Ribble Valley Borough Council
Housing & Development Control

Application no: **3/2021/1153**

Address: **land adjacent to no 9 Old Road Chatburn BB7 4AB**

Proposal: **Proposed dwelling with basement accommodation on an in-fill site adjacent to no 9 Old Road Chatburn, following refused applications 3/2019/0498 and 3/2020/0145.**

Chartered Practice **02**

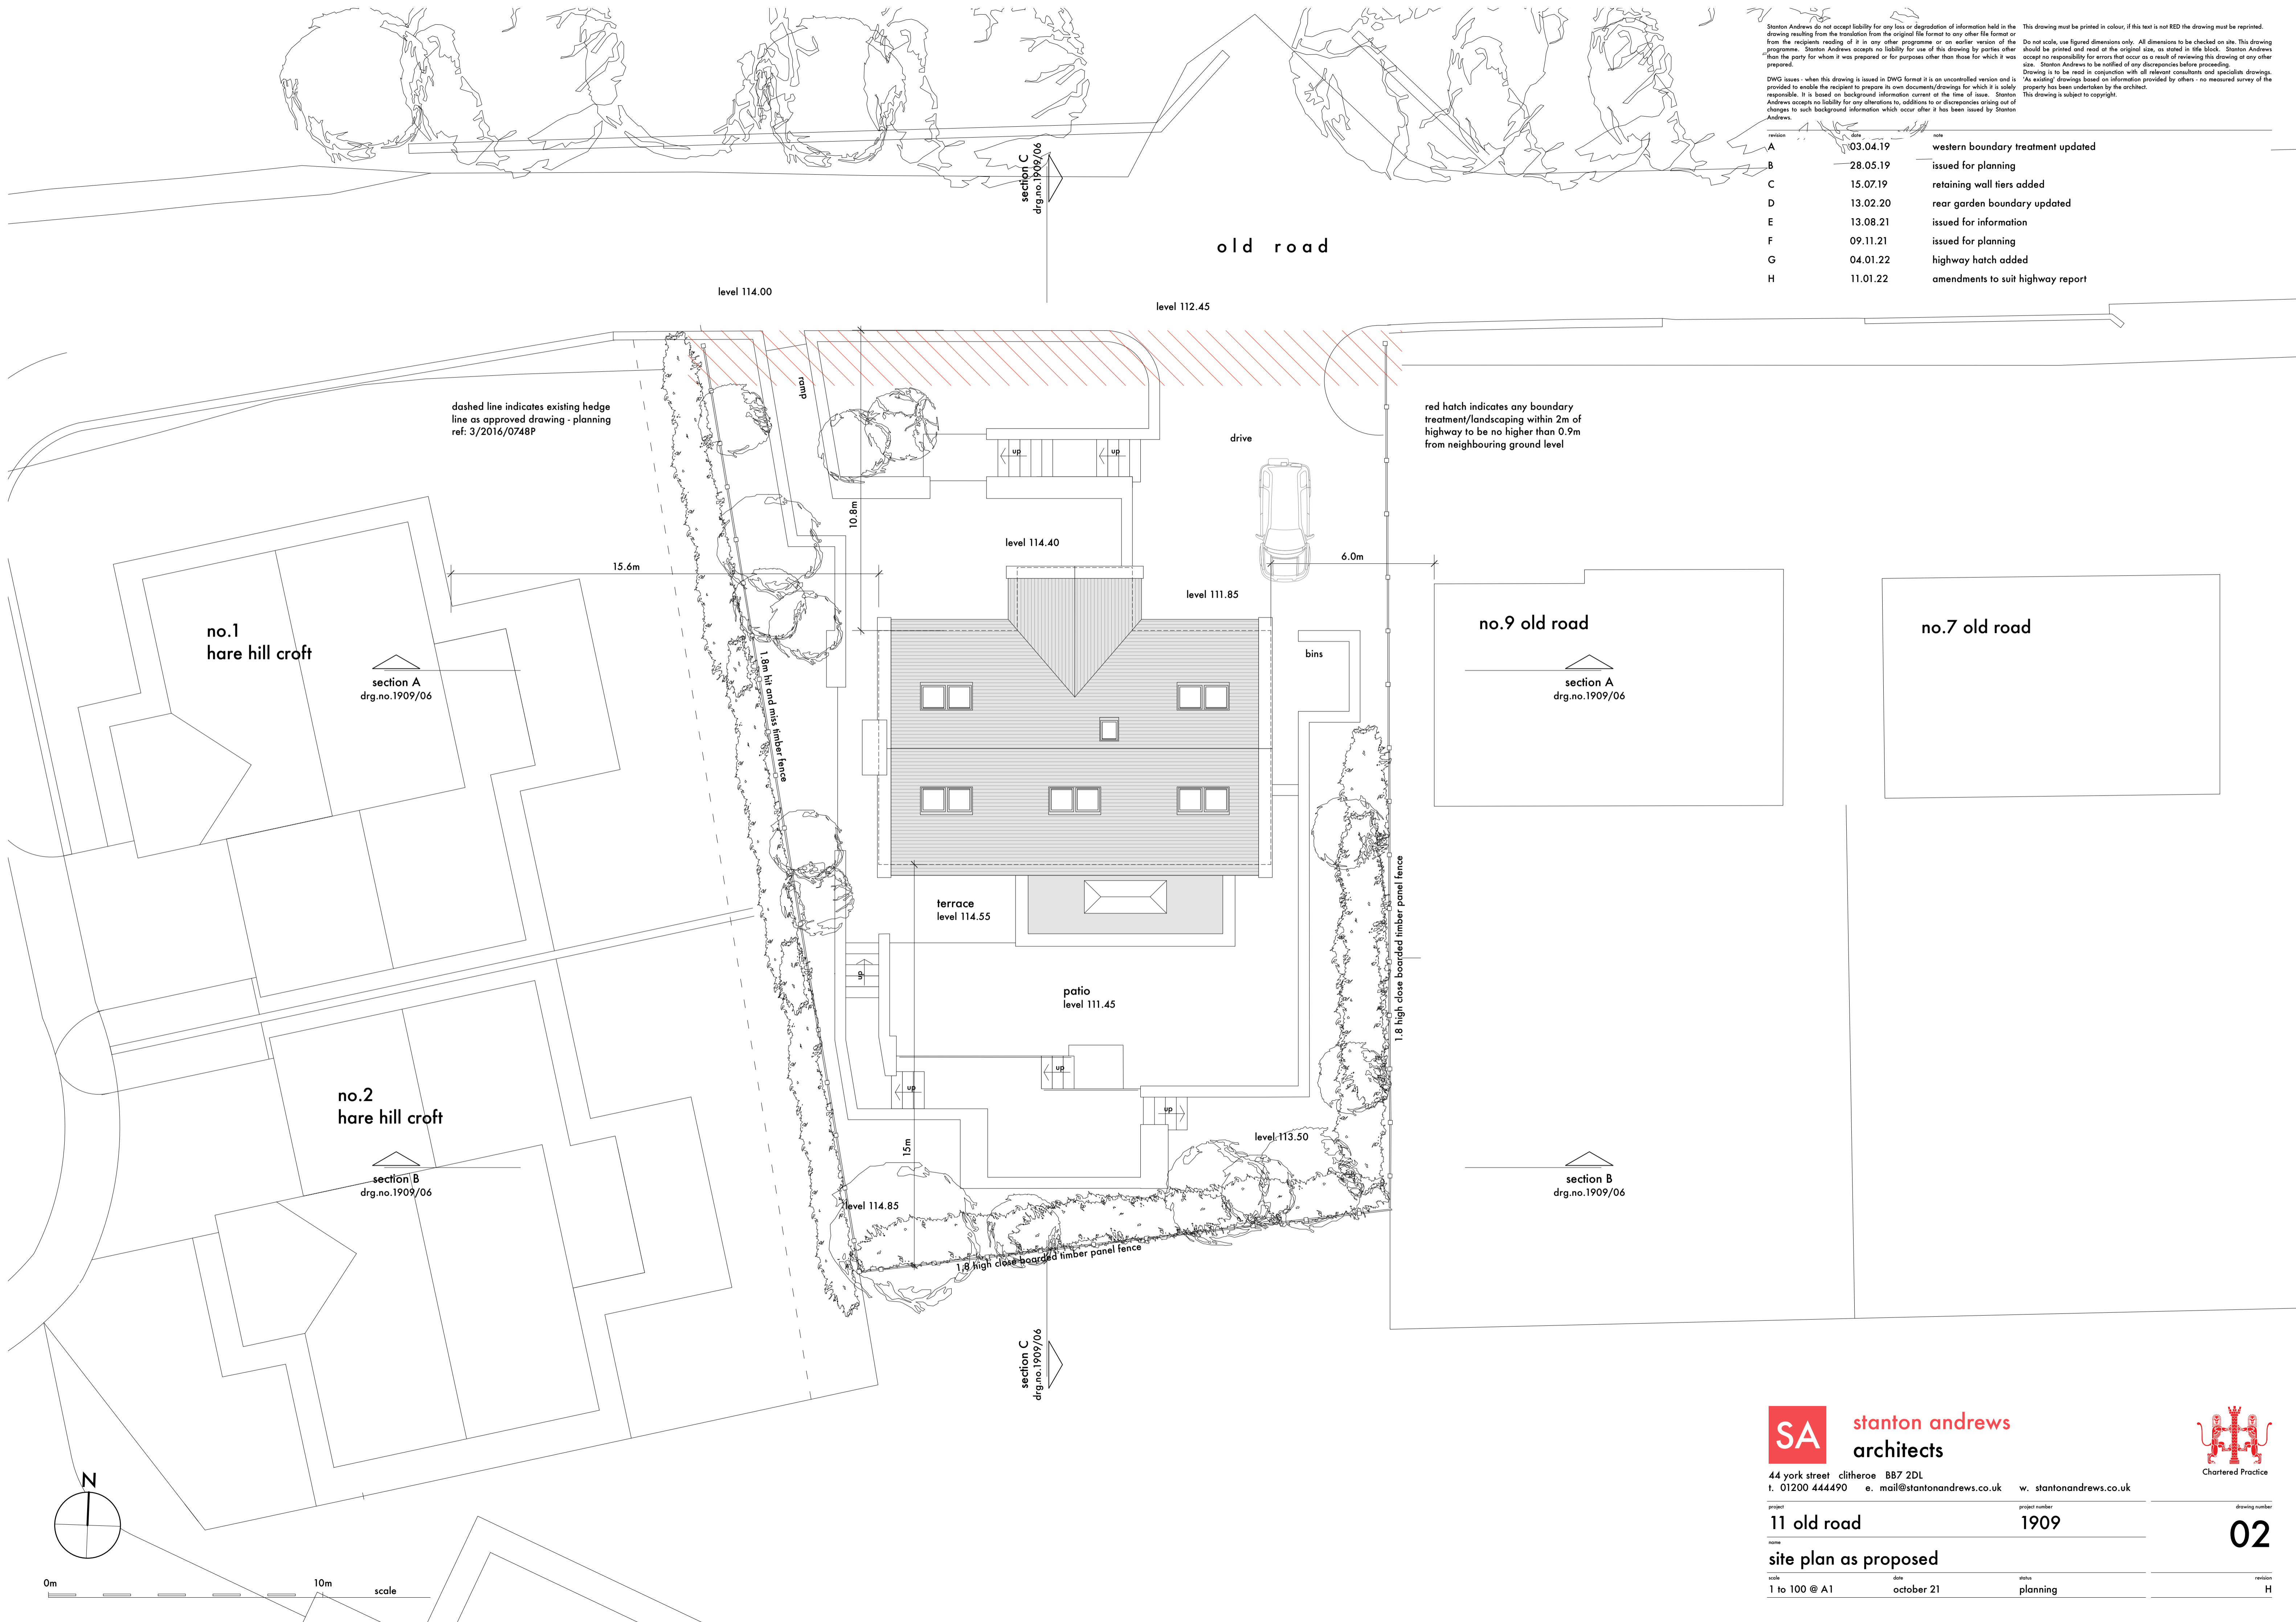
The Applicant has now submitted Stanton Andrews drawing number 02 Rev H titled "Site Plan As Proposed" and a Technical Note provided by DTPC which will be reviewed below.

The LHA have reviewed the proposed access, as shown on Stanton Andrews drawing number 02 Rev H titled "Site Plan As Proposed" and are satisfied that the access arrangements complies with the LHAs guidance.

The LHA have reviewed the drawings provided in the Note and are aware that the site can provide visibility splays of 2m x 30m to the right and 2m x 11.3m to the left of the access.

While these visibility splays do not comply with the LHAs guidance which requires a 30mph road to provide visibility splays of 2m x 43m in both directions. The LHA will accept the shortfall in visibility.

This is because, as discussed in the Technical Note, the road is not used as a through road and the road to the right of the proposed access is only used to serve the 10 dwellings. Therefore, traffic flows along Old Road are extremely low.

The LHA have reviewed Stanton Andrews drawing number 02 Rev H titled "Site Plan As Proposed" and are satisfied that the parking arrangements complies with the LHAs guidance as defined in the Joint Lancashire Structure Plan. Therefore, the LHA have no further comments to make regarding parking.

2. No part of the development hereby permitted shall be occupied until such time as the access arrangements shown on Stanton Andrews drawing number 02 Rev H have been implemented in full.

3. Nothing shall be erected, retained, planted and / or allowed to grow at or above a height of 0.9 metres above the nearside carriageway level which would obstruct the visibility splay. The visibility splays shall be maintained free of obstruction at all times thereafter for the lifetime of the development.

4. The development hereby permitted shall not be occupied until such time as the access drive (and any turning space) has been surfaced with tarmacadam, or similar hard bound material (not loose aggregate) for a distance of at least 5 metres behind the highway boundary and, once provided, shall be so maintained in perpetuity.

5. The development hereby permitted shall not be occupied until such time as the parking and turning facilities have been implemented in accordance with Stanton Andrews drawing number 02 Rev H. Thereafter the onsite parking provision shall be so maintained in perpetuity.
